From: Anita Gardner
Sent: 18 January 2019 11:34
To: Planning.Responses
Subject: FW: A/146/18/PL - New dwelling . Land adjacent to 4 Gladstone Cottages, Angmering
Attachments: 905.01.g Proposed A2.pdf

From: Lauren Willard [REDACTED]
Sent: 17 January 2019 17:42
To: Anita Gardner
Cc: John Moss
Subject: Re: A/146/18/PL - New dwelling . Land adjacent to 4 Gladstone Cottages, Angmering

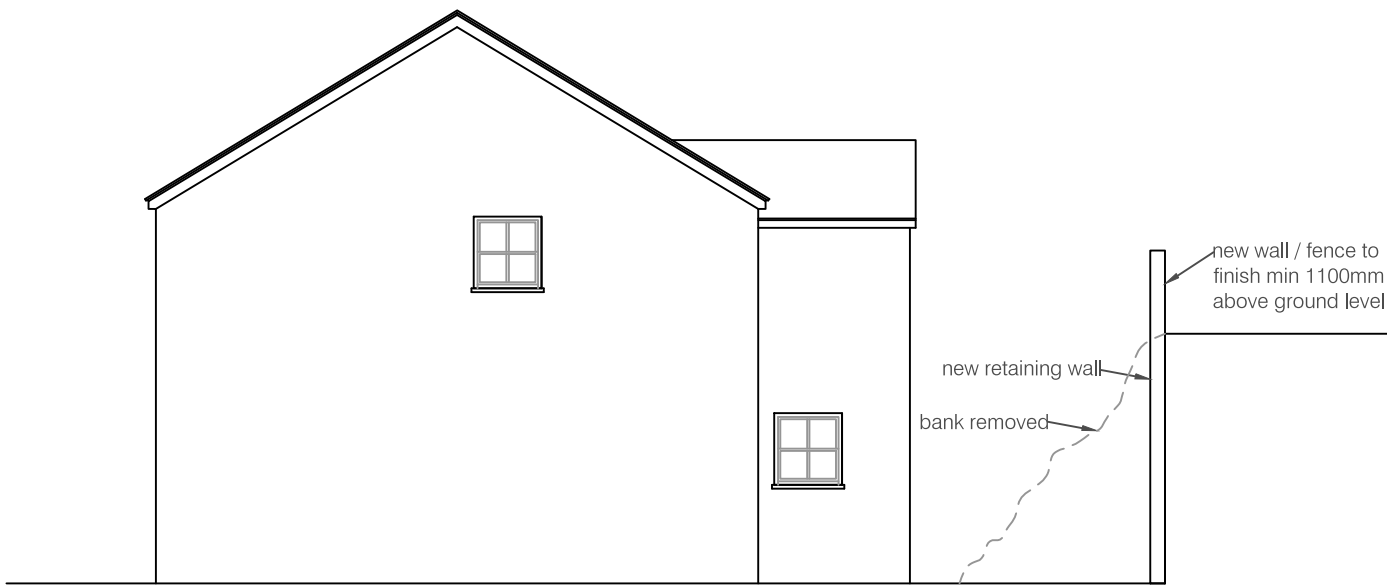
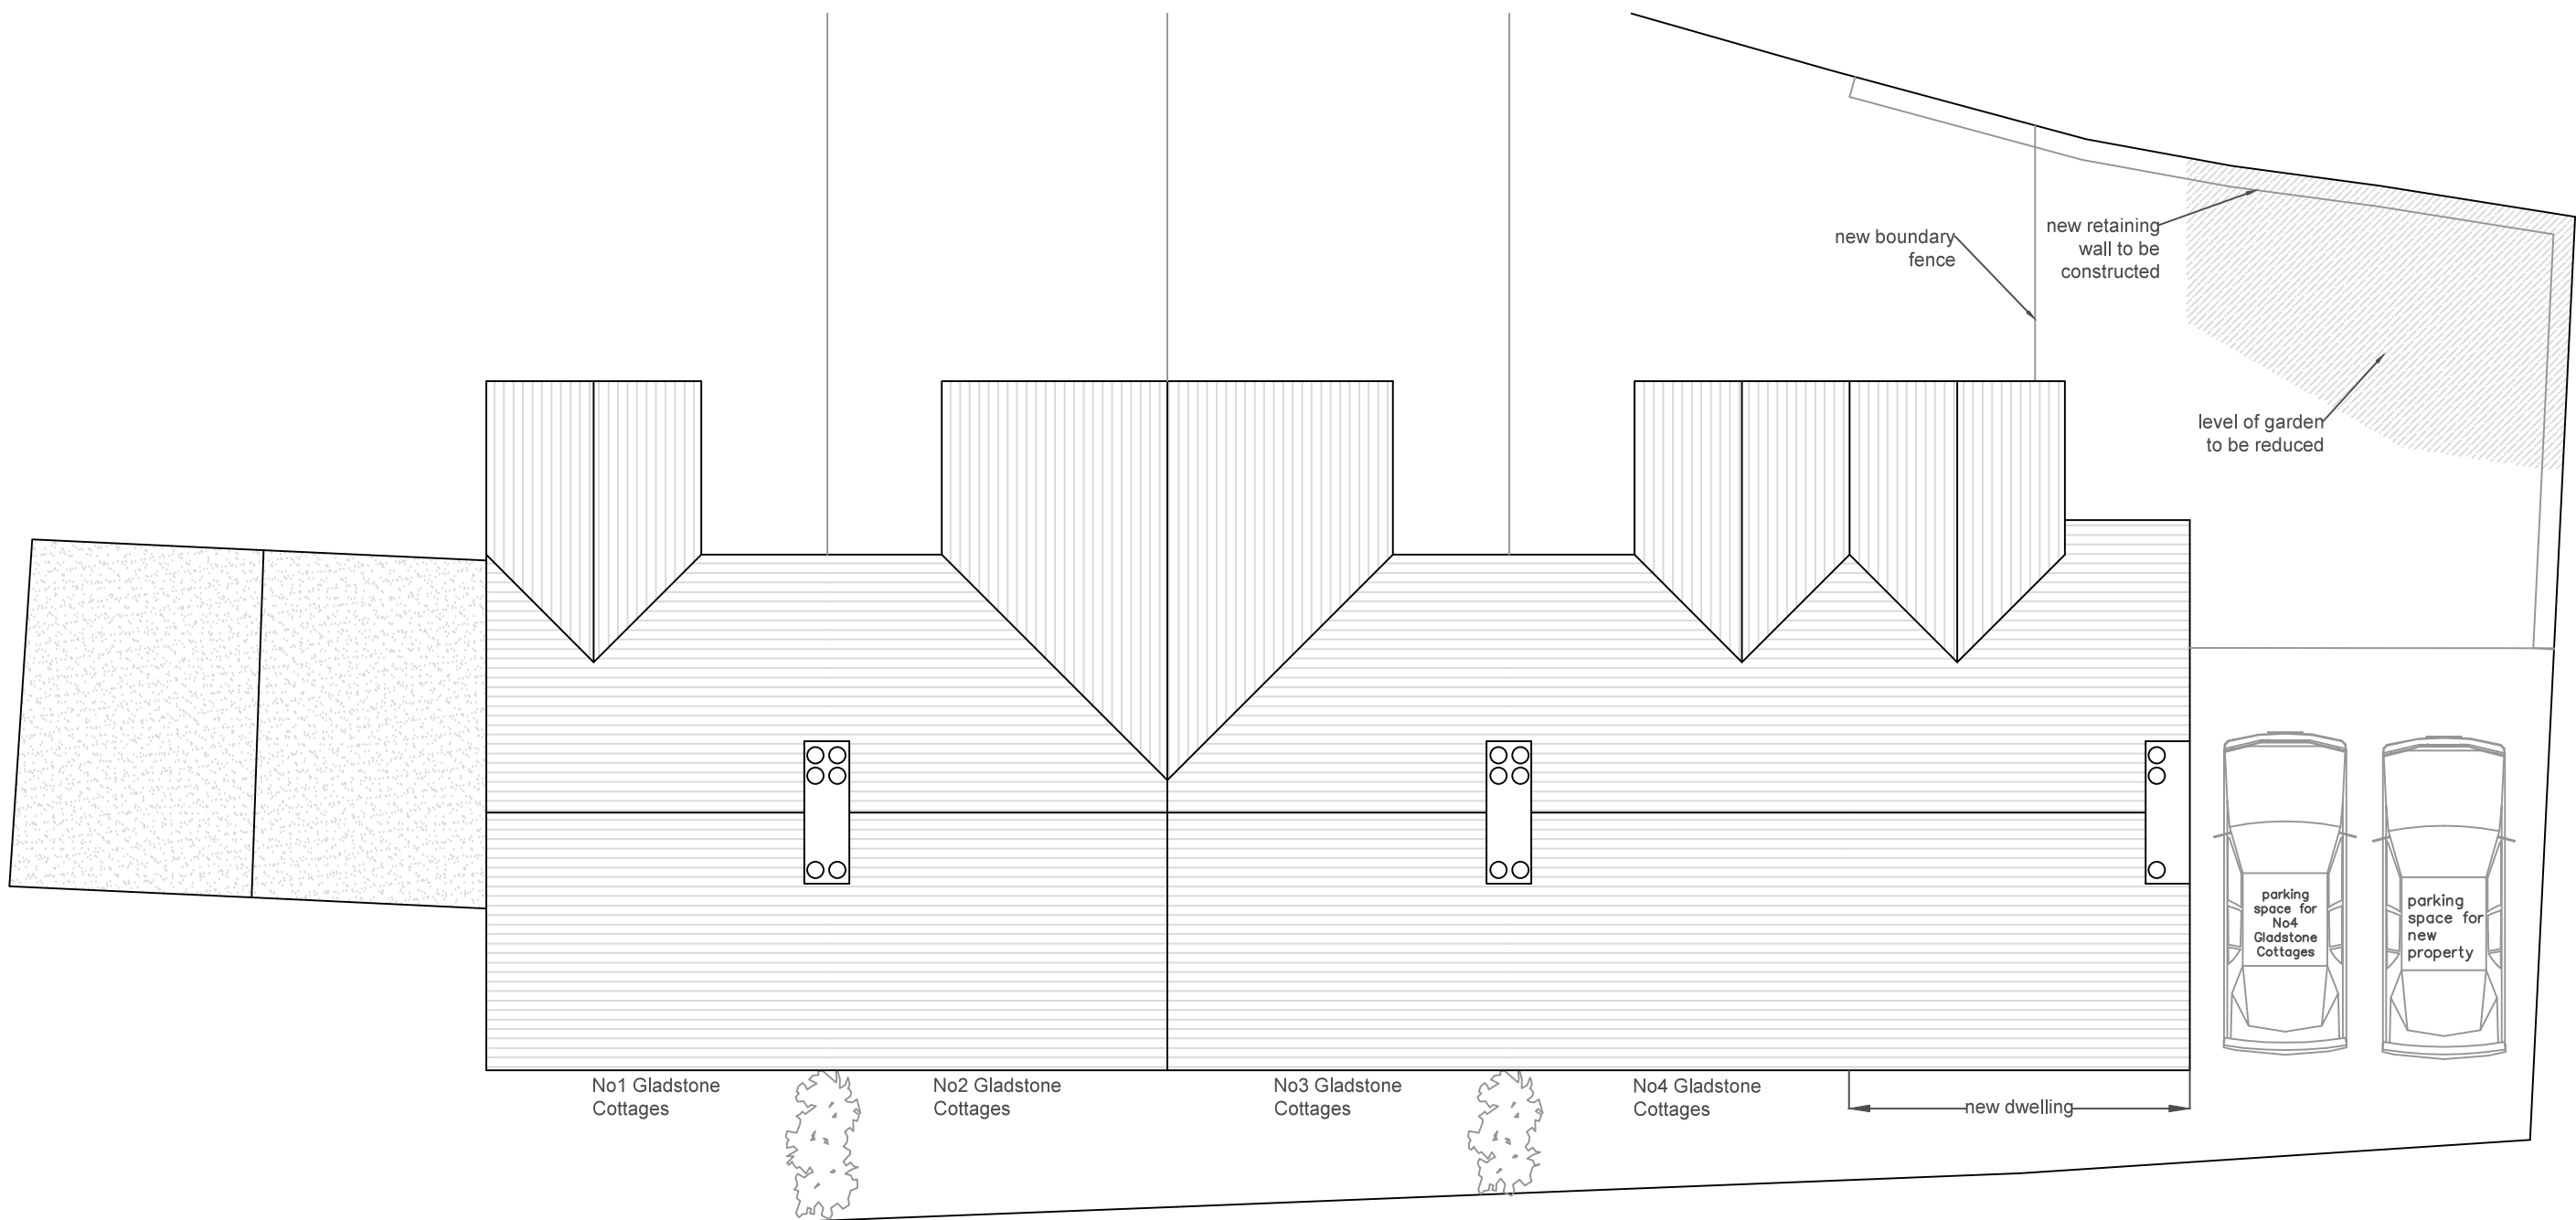
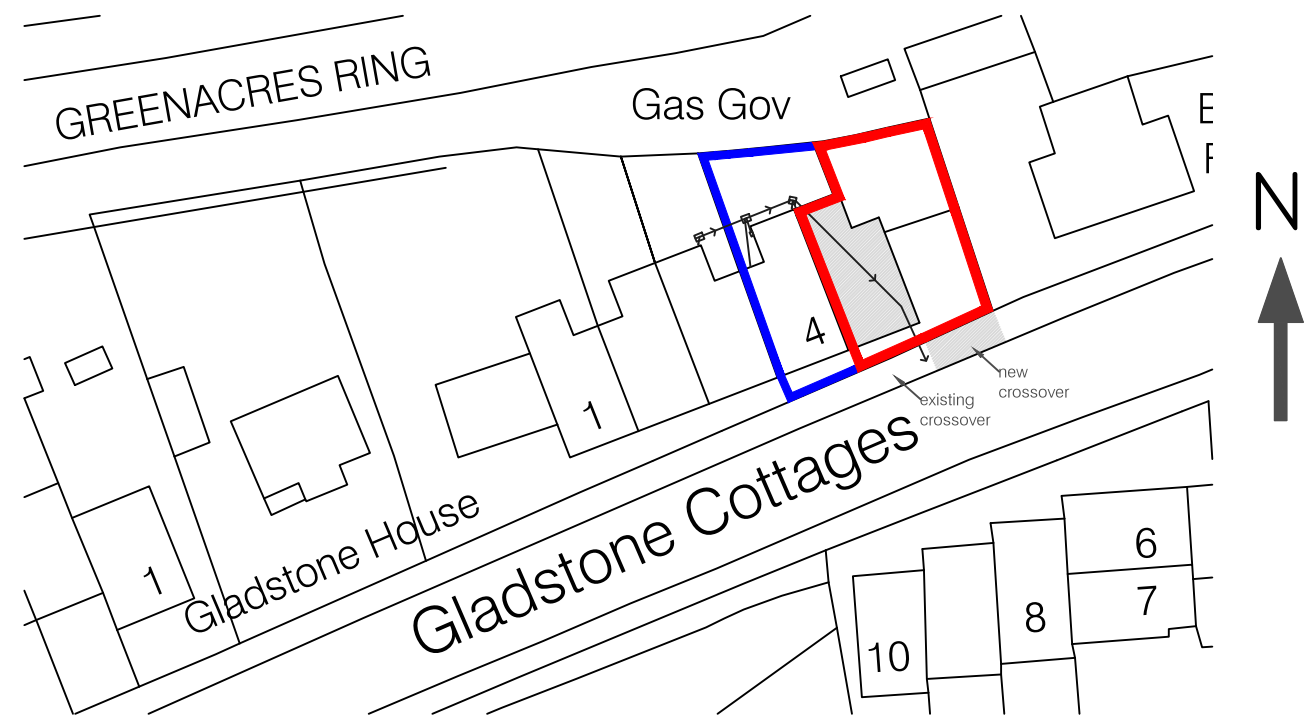
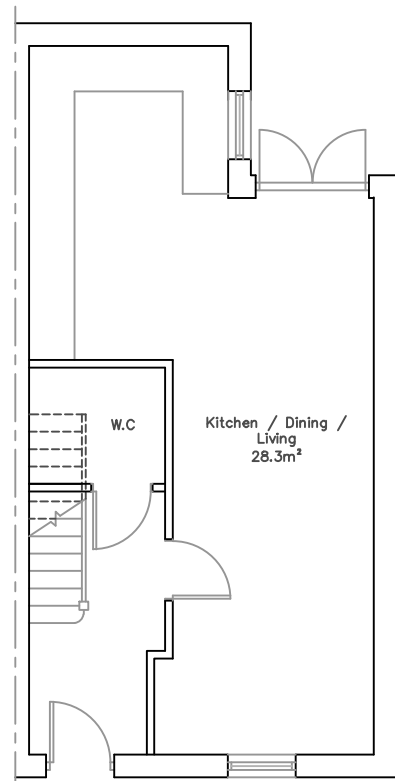
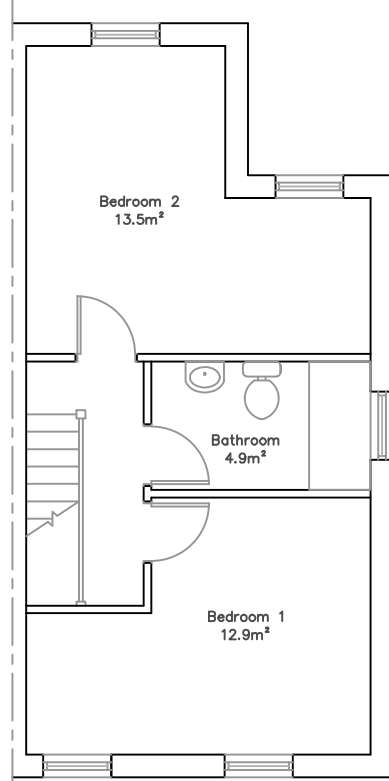
Please find attached the amended drawing which has been revised to show the boundary fence between No.4 and the proposed new dwelling moved over. The two properties now have gardens of a similar area and are in keeping with the gardens of No 2 & No 3. I have annotated one of the rear windows to be obscured and non-opening within 1700mm of finished floor level as we discussed.

I have also added an additional window to the bedroom at the front of the property as I was hoping this could be considered. If this is not acceptable would a high level one on the side elevation be considered?
